Appeal Decision

Appeal Ref: APP/R5510/X/24/3337887

231 Long Lane, Hillingdon, Uxbridge, UB10 9JP

- The application was made under section 192(1)(b) of the Town and Country Planning Act 1990 (as amended).
 - The development for which a certificate of lawful use or development is sought is described as "Enlargement of a dwellinghouse by construction of one additional storey (Application for prior approval under Schedule 2, Part 1, Class AA of the Town and Country Planning (General Permitted Development) Order 2015 (as amended)). This Application is a Re-Application of [Ref: 65967/APP/2022/2863], and follows the Appeal decision Ref: APP/R5510/D/22/3311878."
-

FRONT ELEVATION

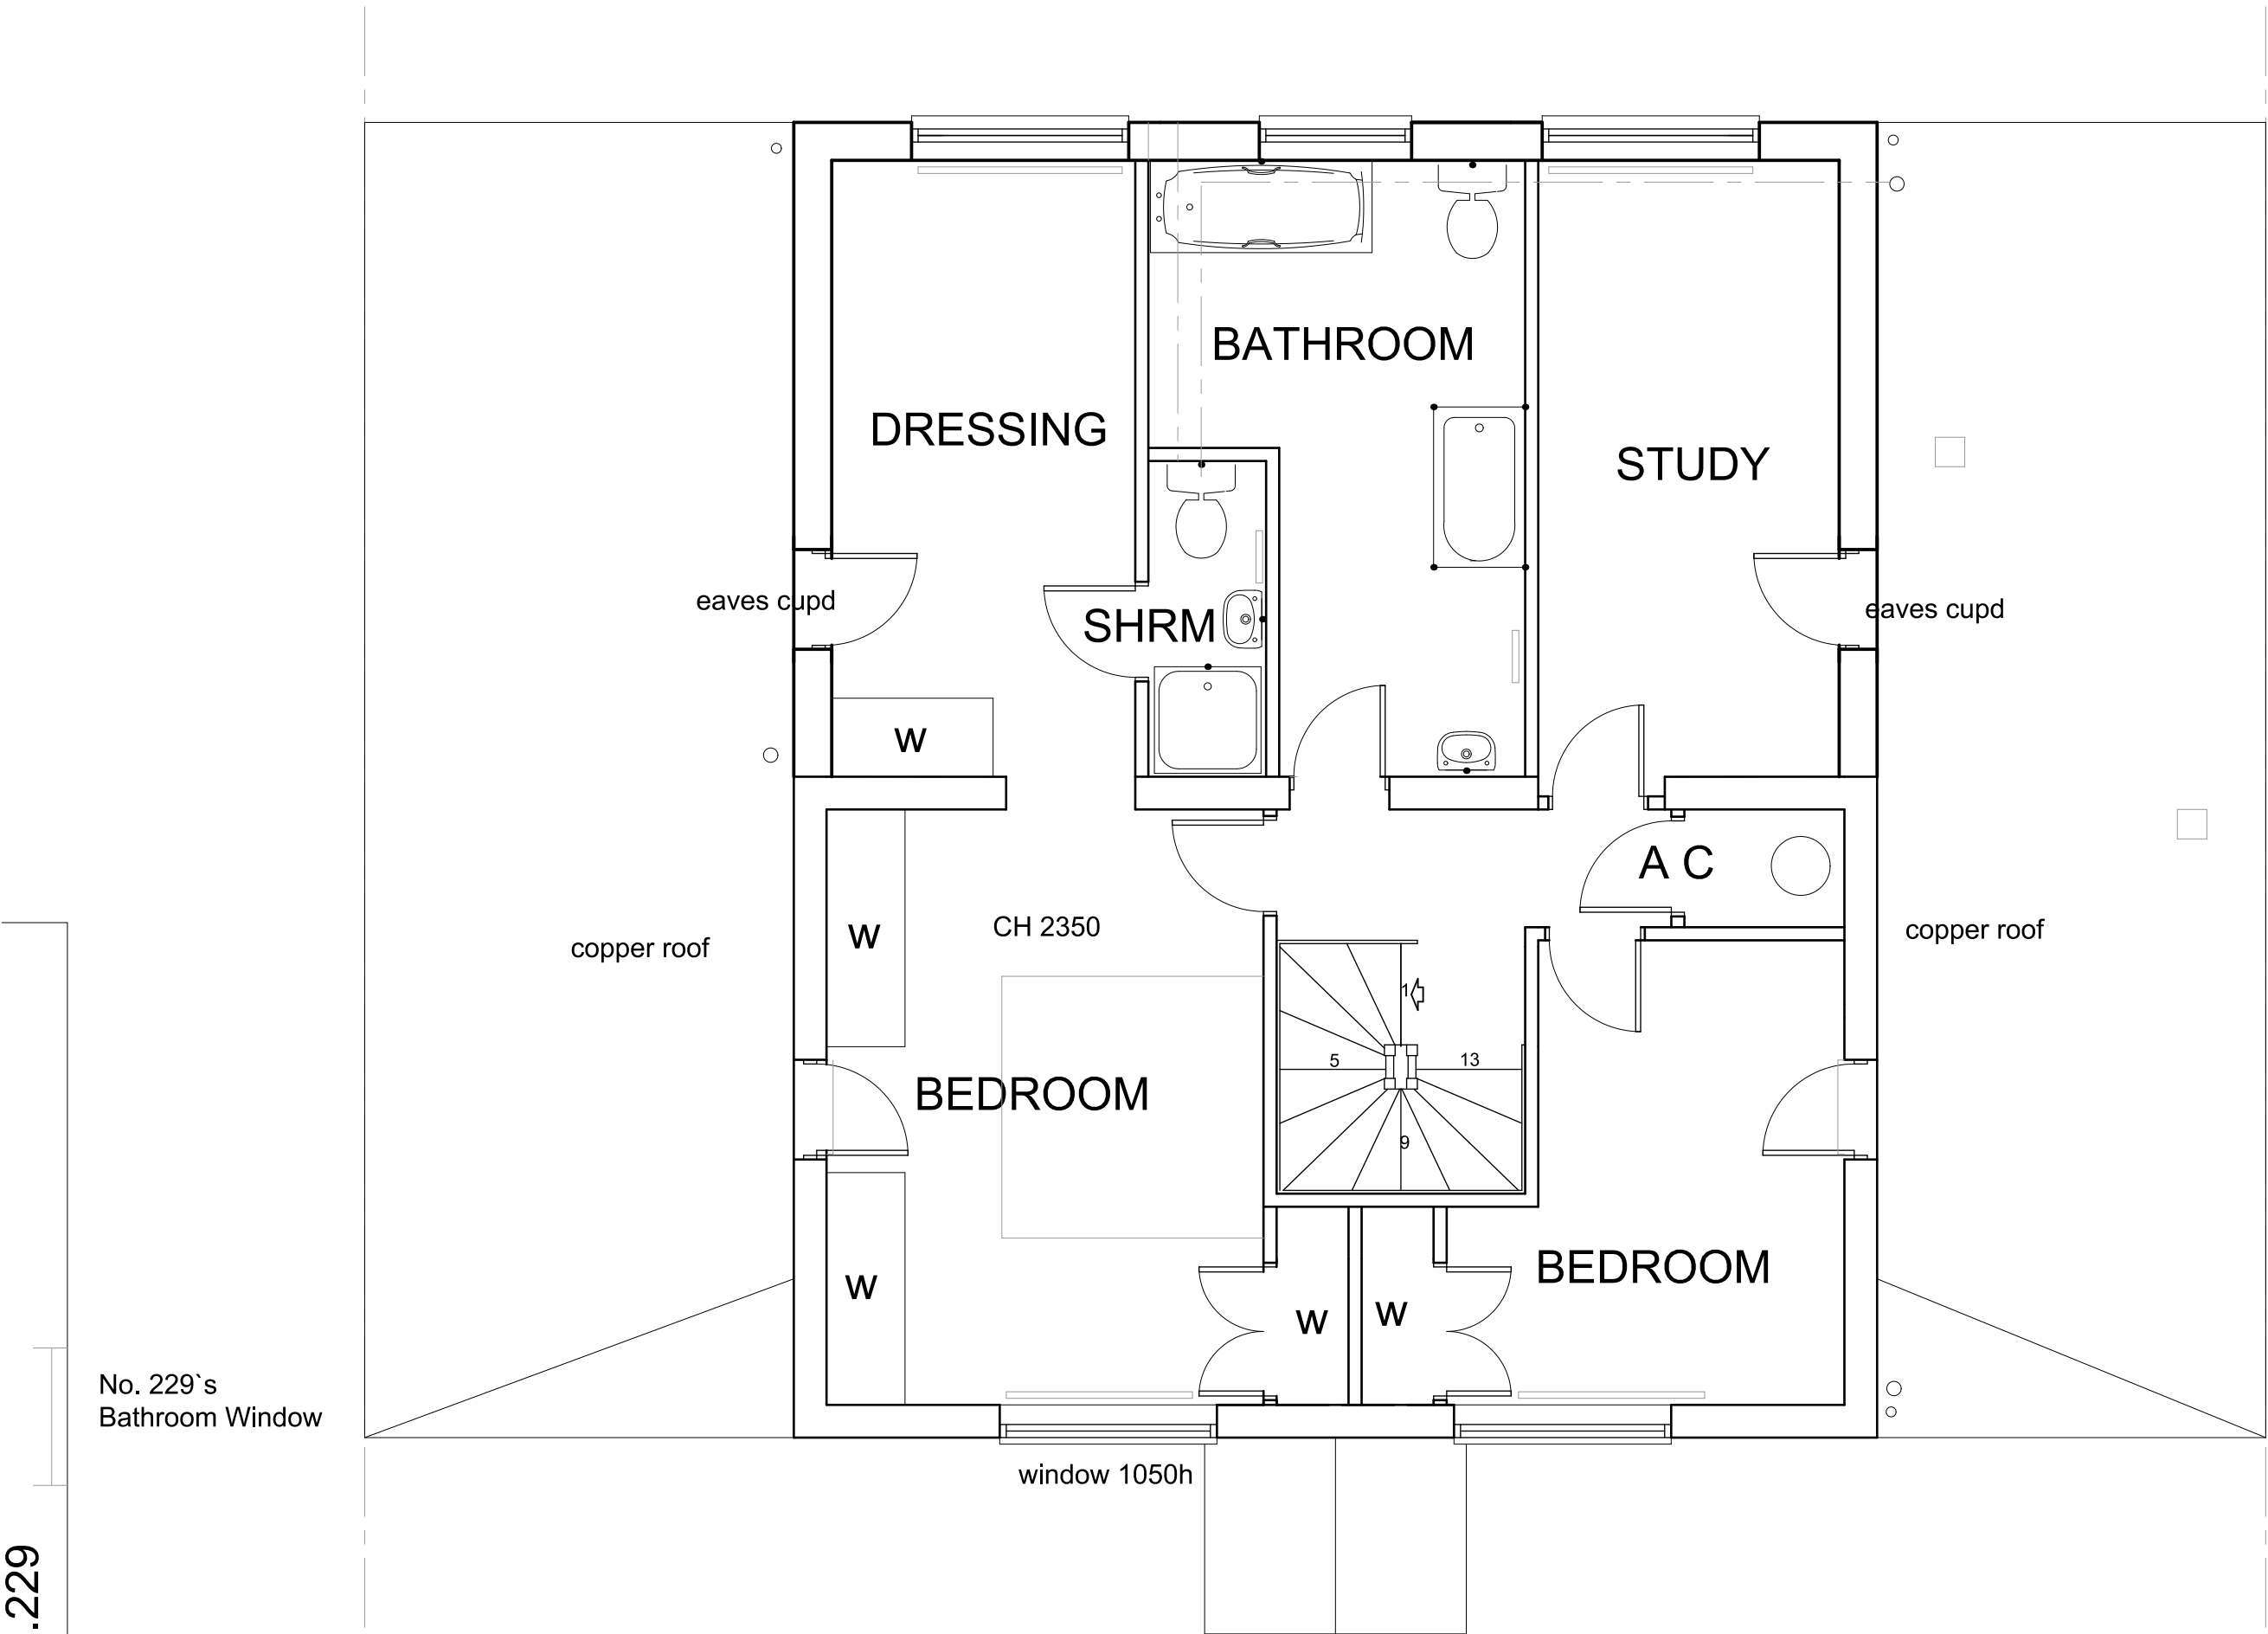
10. The proposal is to add an additional storey to the dwelling, which would increase the ridge height by 2.66m.
11. The appellant has sought to draw my attention to the non-residential uses in the area; however, the stretch of road in which the appeal property is situated, has a residential appearance, even if some of the houses are no longer used for that purpose. Moreover, even if there are three storey scale buildings further along the road, the appeal property is not seen in combination with them.

15. Presently the existing architectural features, including an eaves line sitting directly above the top of the first floor windows, contribute to a visually compact composition. As a result of what is proposed, the elevation, somewhat inevitably, would be elongated with greater expanses of render between architectural features, including the eaves line. The shape of the roof would also significantly change. Overall, there would be a shift to a greater sense of verticality. I cannot therefore agree that the architectural composition of the existing property would be preserved. Nevertheless, taken in isolation, that isn't necessarily unacceptable.

16. I appreciate the appellant's intention to build to the highest standards, but the harm primarily arises from the relative scale of the proposal, which would abruptly and significantly protrude above the existing height parameters of this part of Long Lane, and in doing so unacceptably disrupt the rhythm and consistency of its prevailing two storey scale. As a result, the dwelling would appear as an unduly prominent and discordant feature within the street scene.

19. I appreciate that the appellant has amended the scheme in an attempt to address the concerns over the previous scheme dismissed at appeal², but I conclude, for the reasons given above, that unacceptable harm would still arise to the external appearance of the dwellinghouse. I therefore find that the development would not be acceptable in relation to Paragraph AA.2.(3)(a)(ii) of the GPDO.

22. The neighbouring property at No 229 Long Lane has a first floor side window facing towards the appeal dwelling. However, because of its relative position and the proposed hipped roof design, it is unlikely that any reduction to the amount of light reaching that window would be unacceptable, particularly as it serves a non-habitable room (a bathroom).
